Club Burwood RSL – Planning Proposal Modification - Burwood Council Traffic Comments

This letter has been prepared to address the comments received from Council's traffic engineers in their memorandum dated 17th December 2020.

Figure 26 - Proposed Car Wash Layout

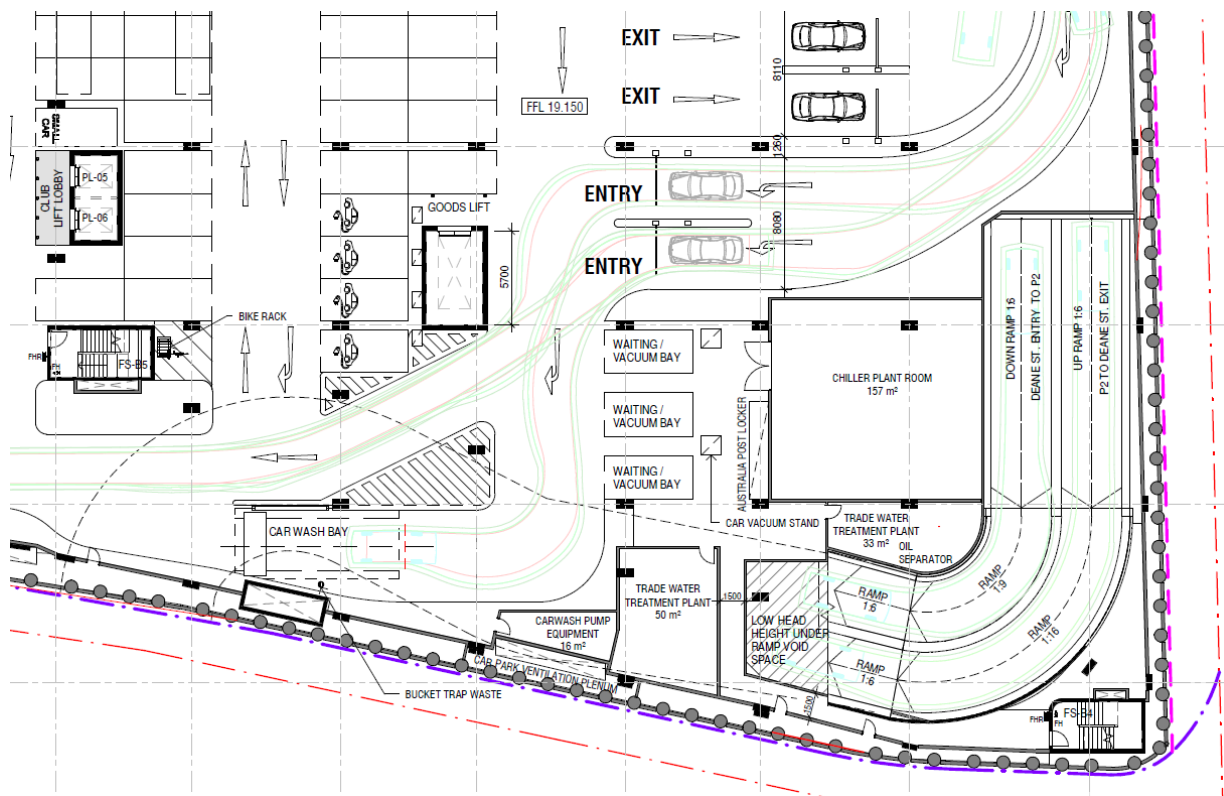
Concern is raised regarding the location of the automated car wash bay and the lack of queue storage available before impacting on circulating traffic, in particular given its location near the bottom of the entry ramp/boom gate. In this regard further details are required regarding its operation.

The car wash is proposed as an additional service to visitors of the club and as such is provided within the basement car park, within the confines of the access control system. It is intended that as an ancillary service, the automated car wash will be able to accommodate the demand without causing queuing within the car park. The demand will be fairly low, plus the proposed automatic car wash specs indicate an average of 6 minutes to wash a car, meaning a turnover of 10 vehicles per hour.

The club has prepared a plan of management for the entire club building, including a section on the operation of the car wash (see final page of this letter). It is in the club's best interest to ensure that the car park operates efficiently, and this has been a key driver in the design of the car park. As such, the Plan of management requires manual intervention and monitoring should there be any risk of impacts on the car park circulation.
